MMC: FW: Shaws TCP (CMP)

Attached are our responses to the DPW's comments. Our approximate durations for each phase of work are as follows. Let me know if you would like any additional information.

**NOTES:**

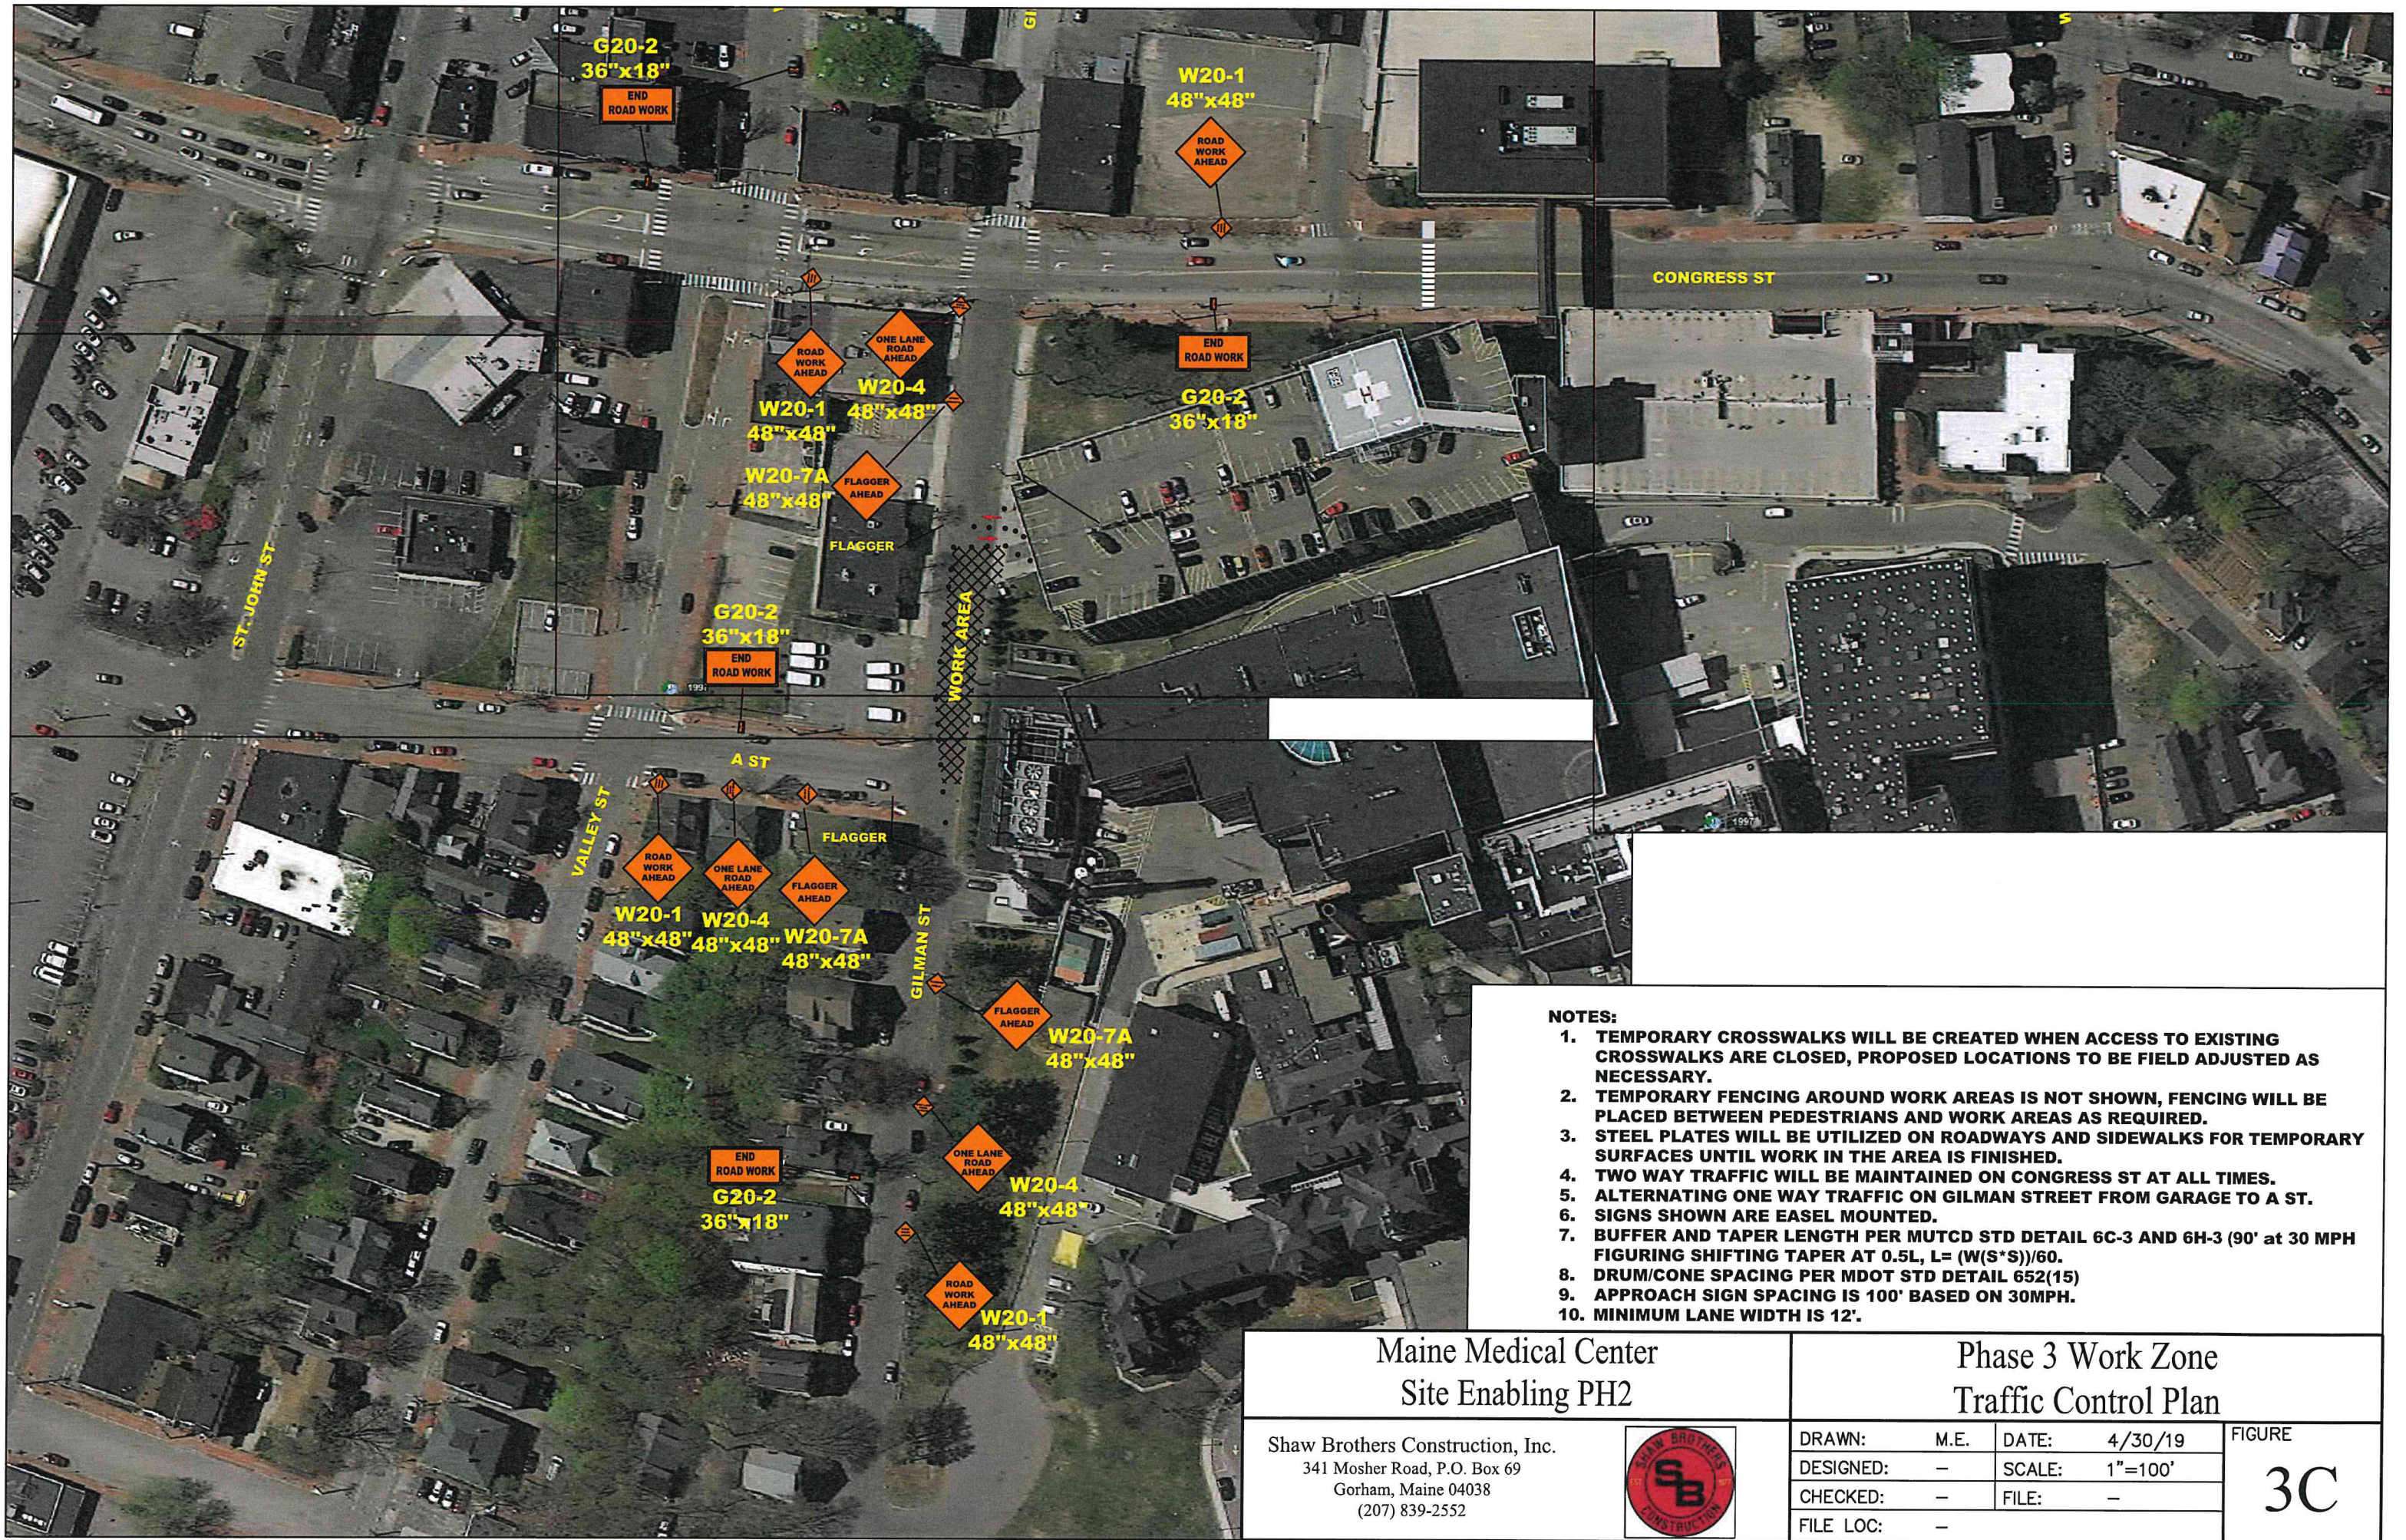
One basic comment from Tom Errico was re labeling the Shaw graphics with approximate timelines, but I don't believe this has been addressed (unless I'm missing something?). We do have timelines in the Turner documents, but these don't match up entirely with these plans. Can you guys address this quickly?

Phase #1: 3-4 weeks

Phase #2: 8-10 weeks

Phase #3: 4-6 weeks
